**RE: Commercial & Apartment Building – Phase I  
4<sup>th</sup> St NW and Freeman Ave NW  
Grading and Drainage Plan  
Engineer’s Stamp Date 10-9-2015 (File: G14D066)**

Based upon the information received on 10-9-2015, the following items need to be addressed prior to Building Permit and Work Order (see comment #5) approval. Separate Grading and Paving permits are not typically required for small commercial developments.

11/23/2013 DATE 10/5/15

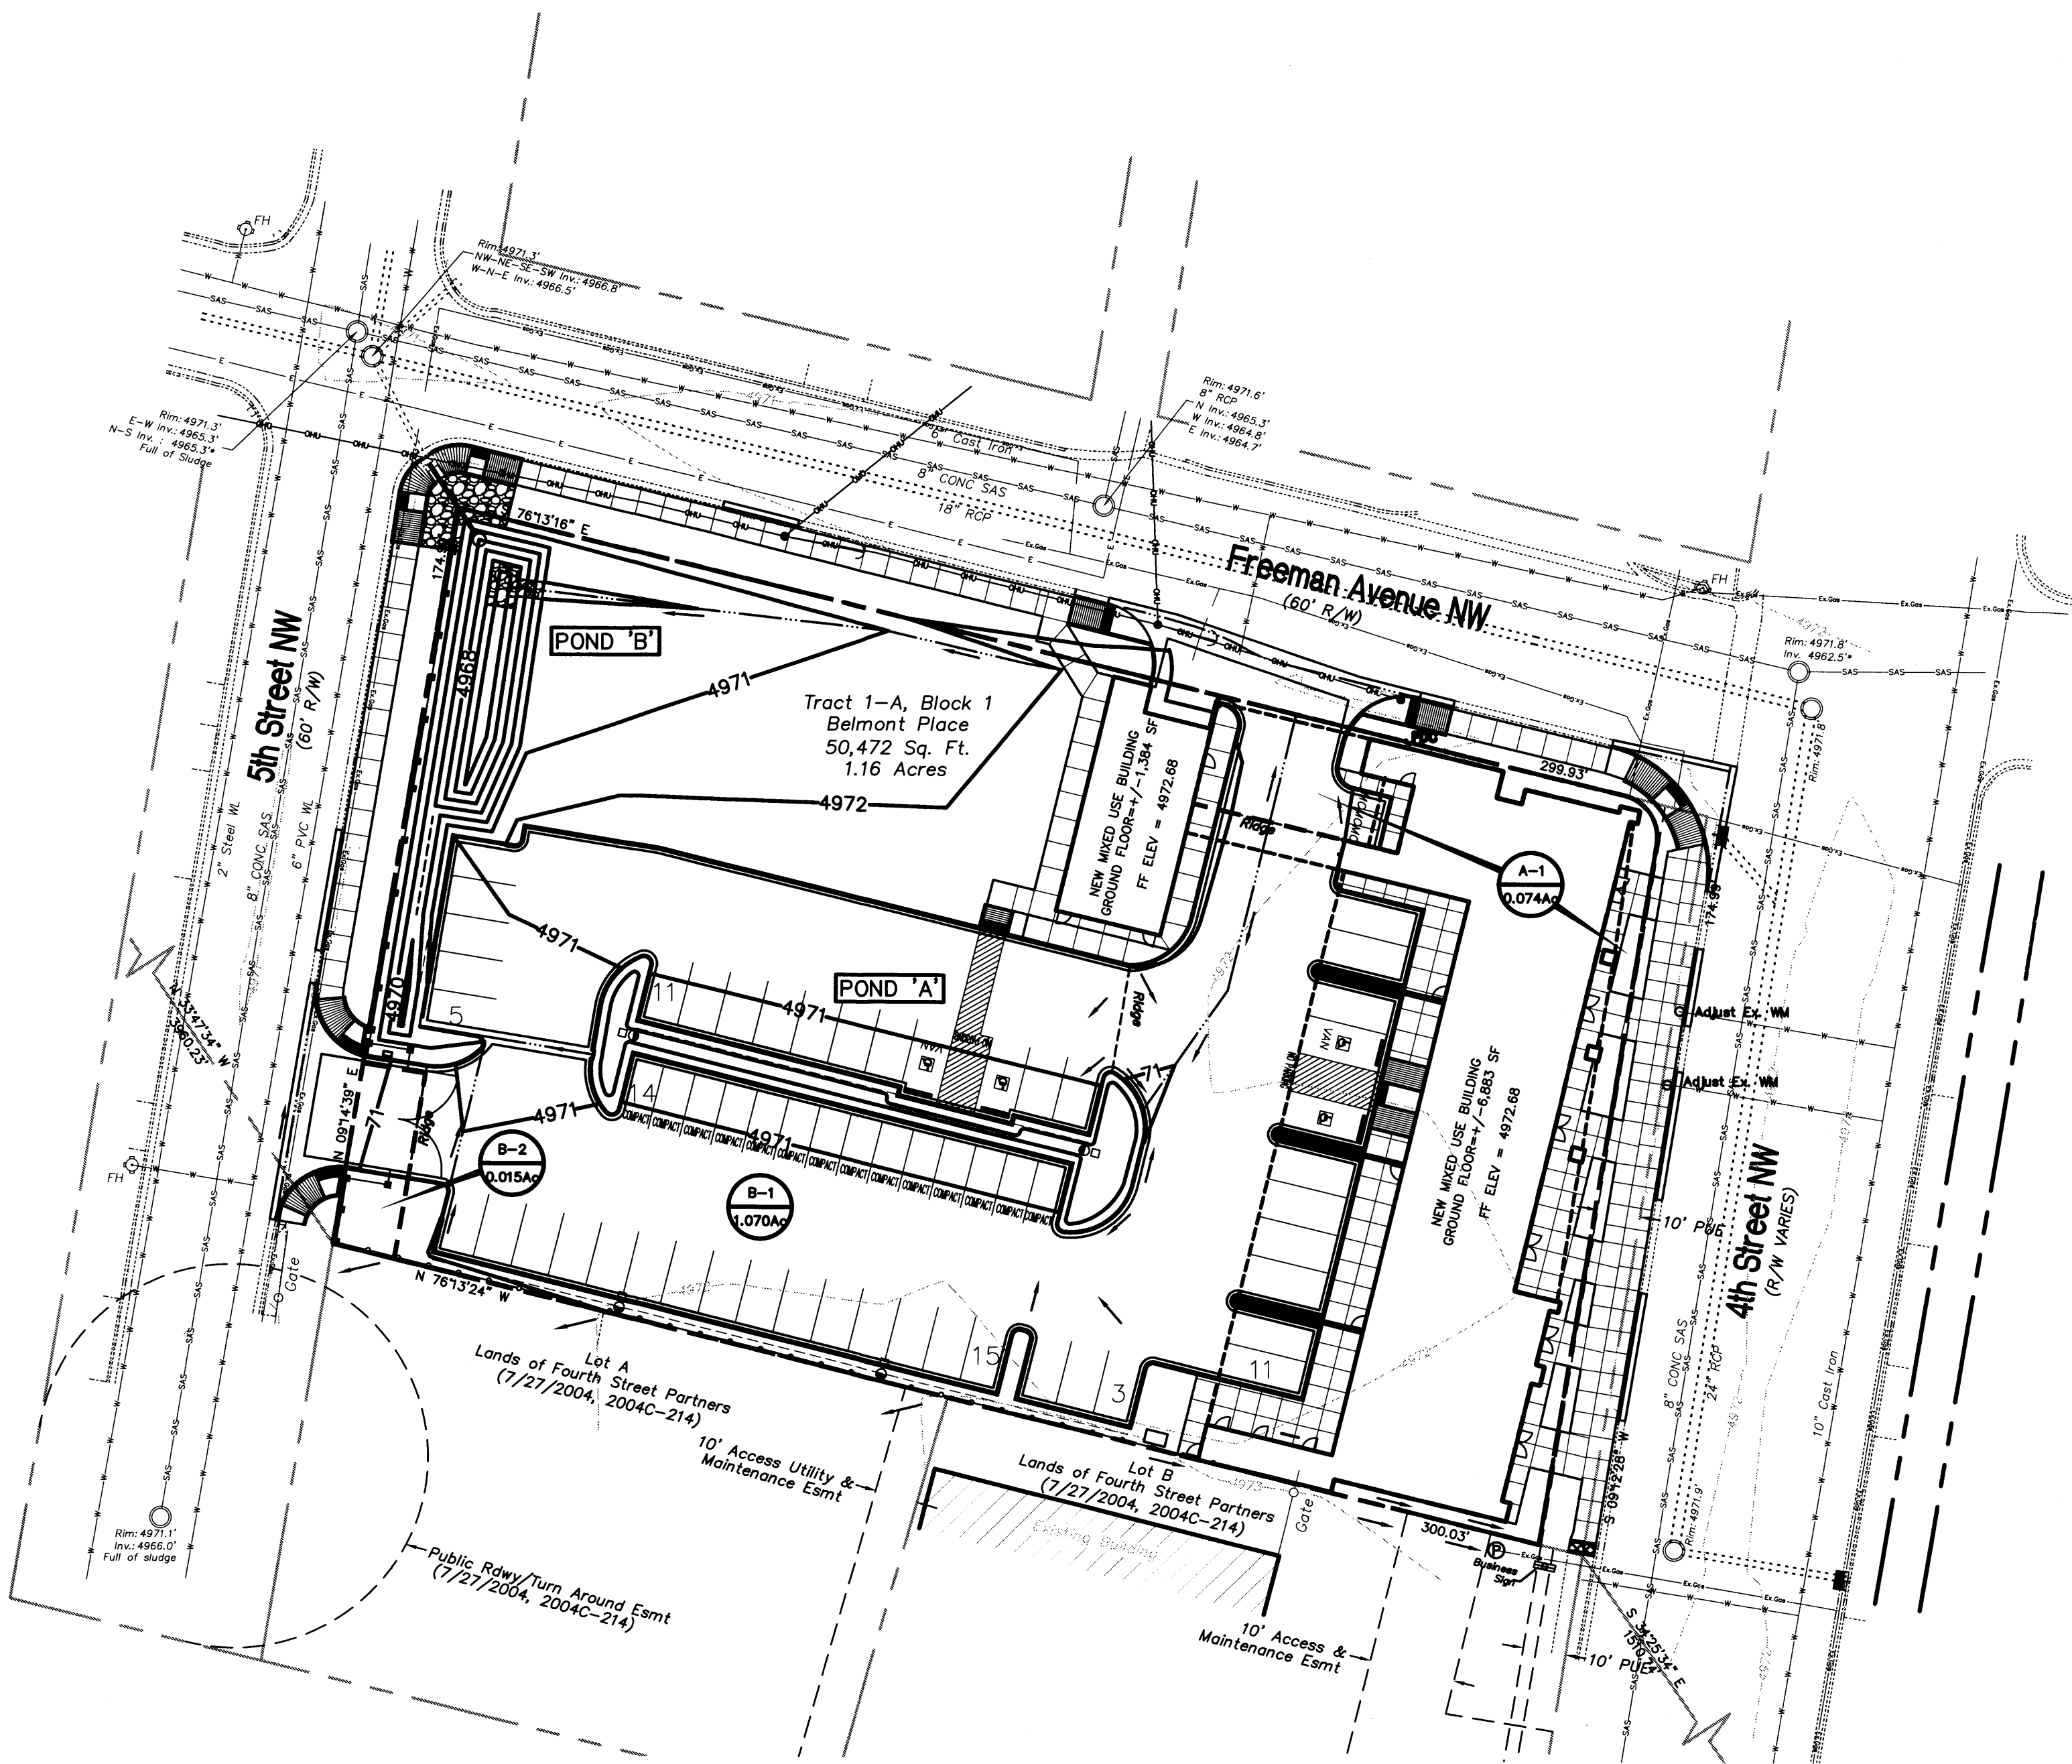
2. Pond ‘B’ needs to show an emergency spillway.
3. Call out the curb openings for both ponds, and the pond bottom elevation for Pond ‘A’.
4. A Work Order (not an SO-19) will need to be processed for the improvements to the City Right of Way. The Work Order will require a Floodplain Construction permit (NW corner of 5<sup>th</sup> and Freeman is in Zone AH).

5. Please include a detail of the pond outfall (the referenced "Quick Drain" can continue to just be referenced by product name/number).
6. 8" PVC is not allowed for the pipe outfall that extends into City Right of Way; instead, 12" High Performance Polypropylene Pipe may be used. The approval letter to ADS from the City Engineer and the Standard Trench Installation Detail are enclosed for reference.
7. Call out a flush transition from the sidewalk culvert surface to the existing surface at the SE corner of the project.
8. Be aware that this plan does not appear to have addressed comments from Transportation, such as minimum sidewalk widths and wheelchair ramp layouts, which will be required through the TCL review.

DRAWING TITLE			
Drainage Management Plan			
SEAL 	DESIGNED	JTW	PROJECT NO WE2014059
	DRAWN	JTW	SCALE See Plan
	CHECKED	JTW	DRAWING NO
	REVIEWED	JTW	DATE 10/5/15
			C4 OF 6

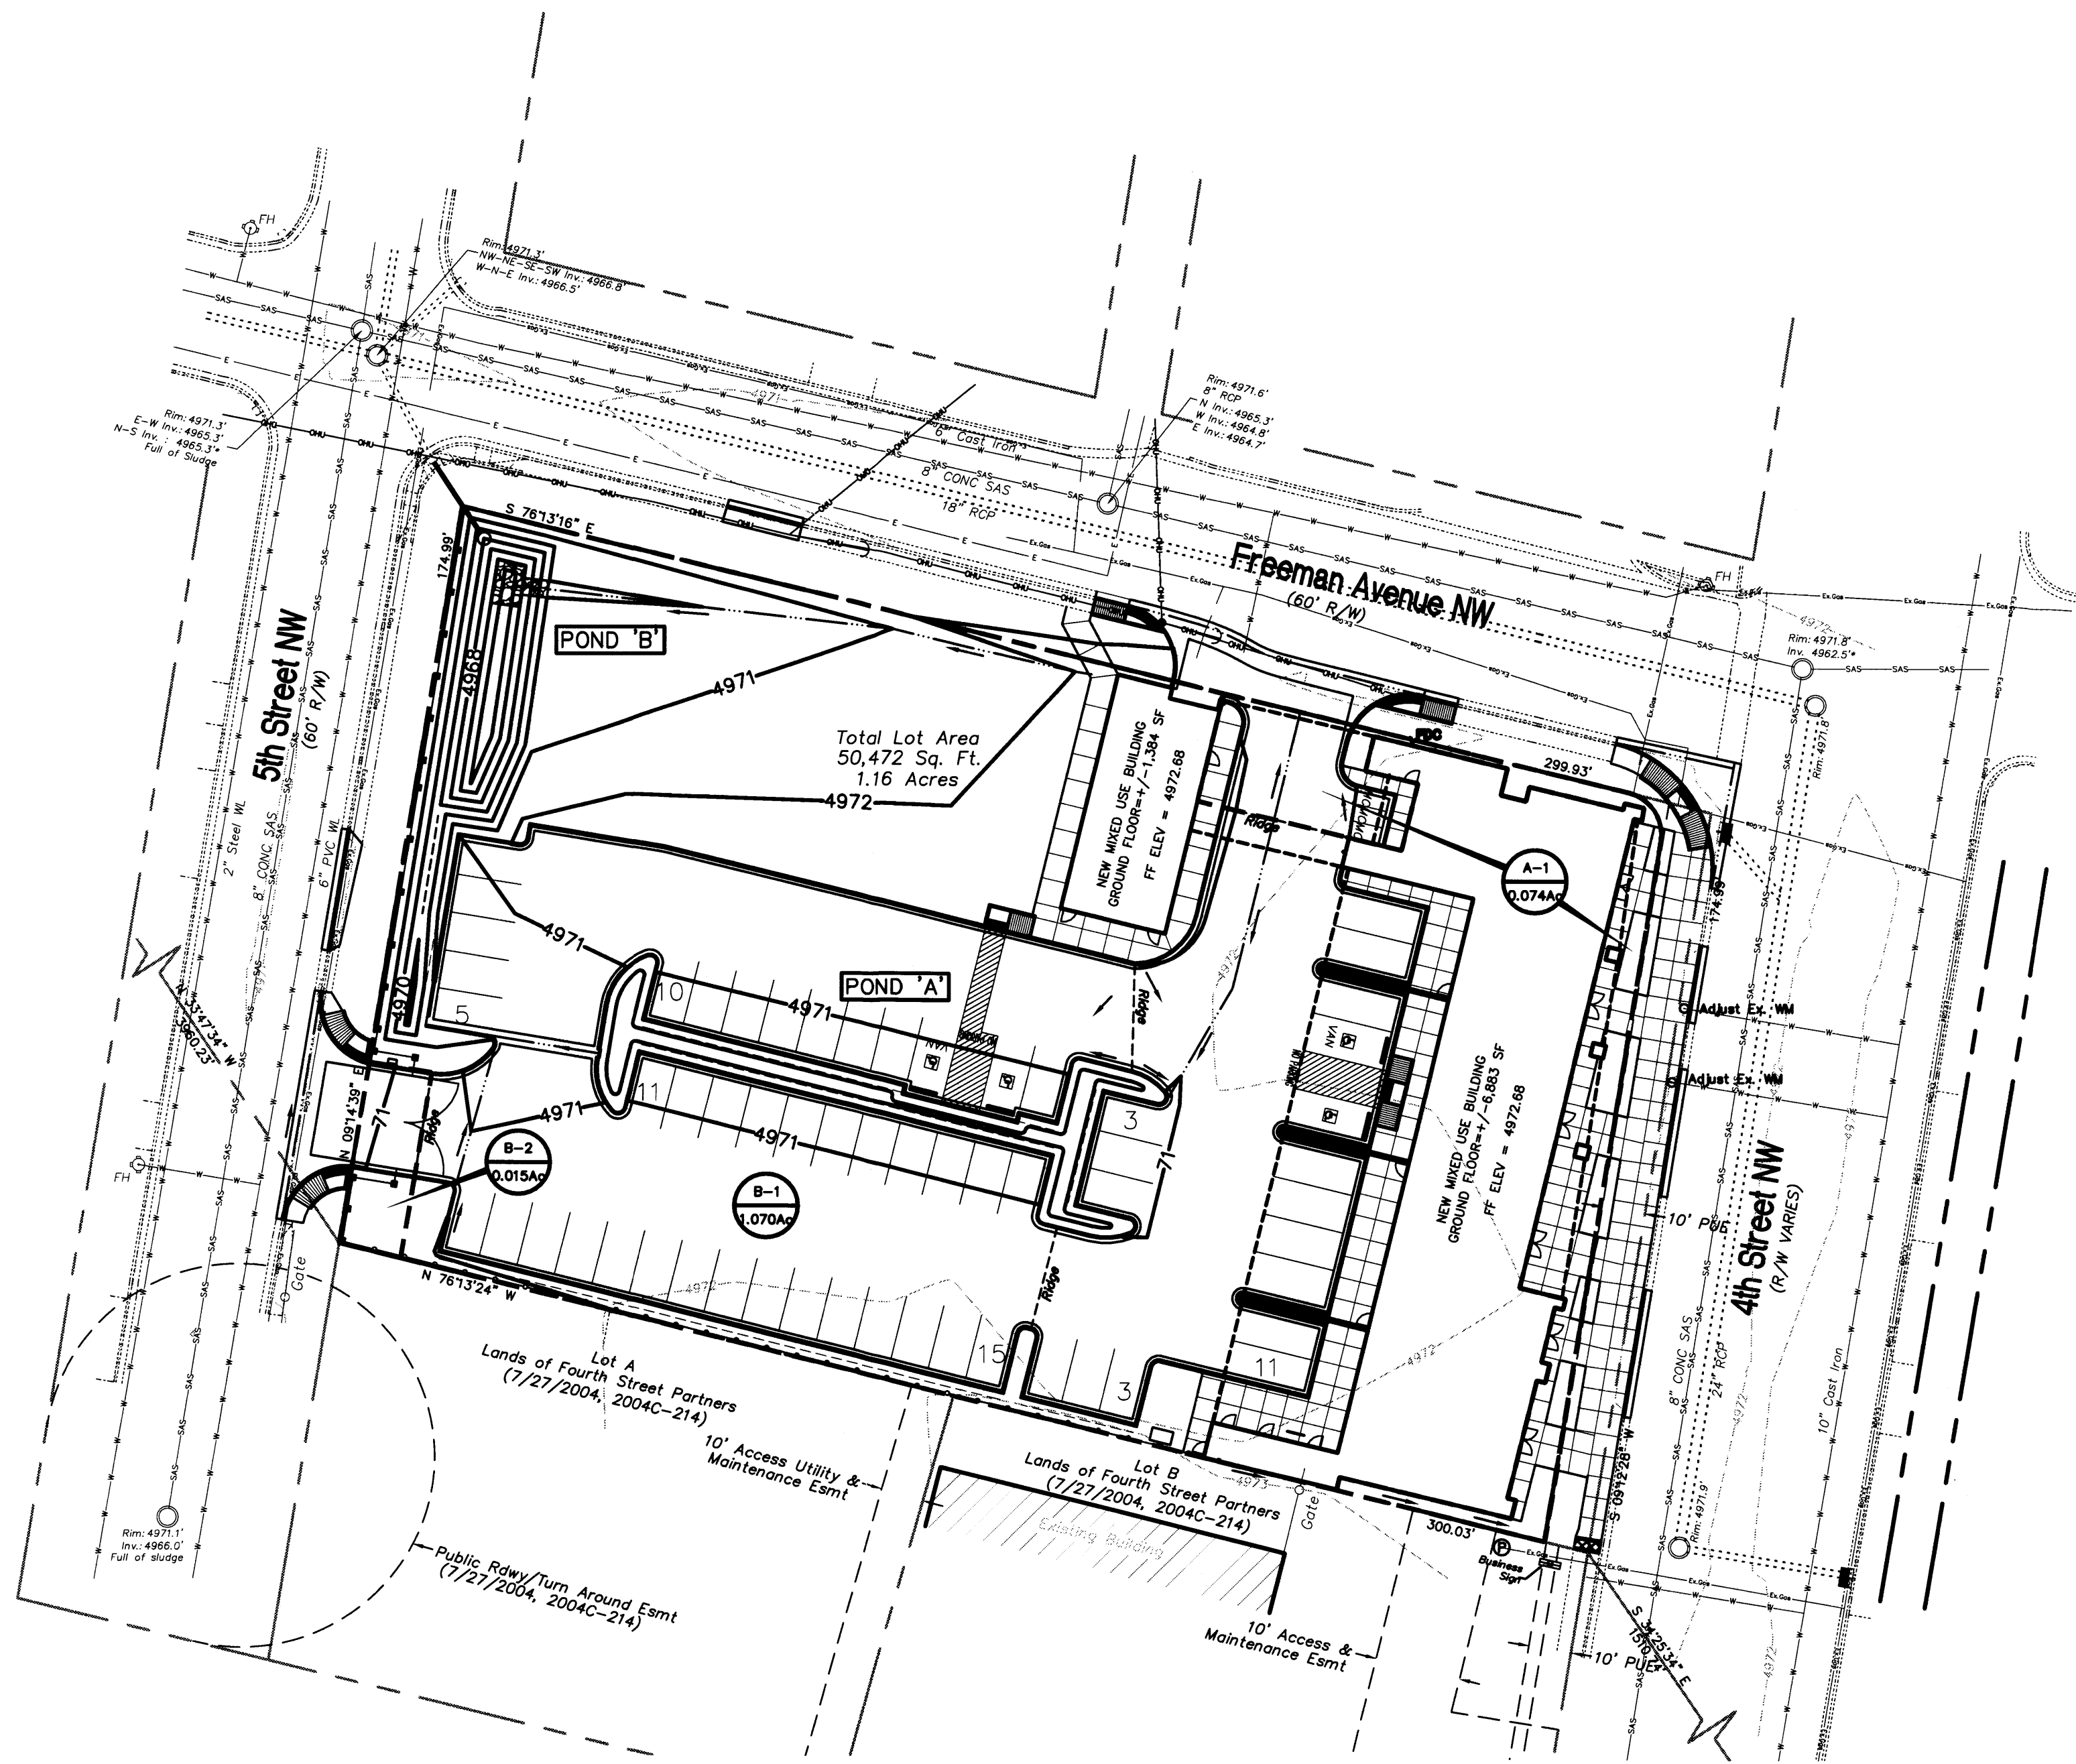
1. The drainage plan language on Sheet C4 states that this development will accept “any offsite flows from the south as needed”. It’s not clear how flows from the south would enter this project with the addition of curb along the southern edge. However, if flows *will* pass through this property, then they need to be quantified and accounted for to ensure the pond operates as intended (at least estimated, in the absence of a drainage report and detailed topographic information for the adjacent property).

- a. A private drainage easement will likely be necessary if flows are planned to pass through the property, it does not appear that one exists in the plat recently presented at DRB.
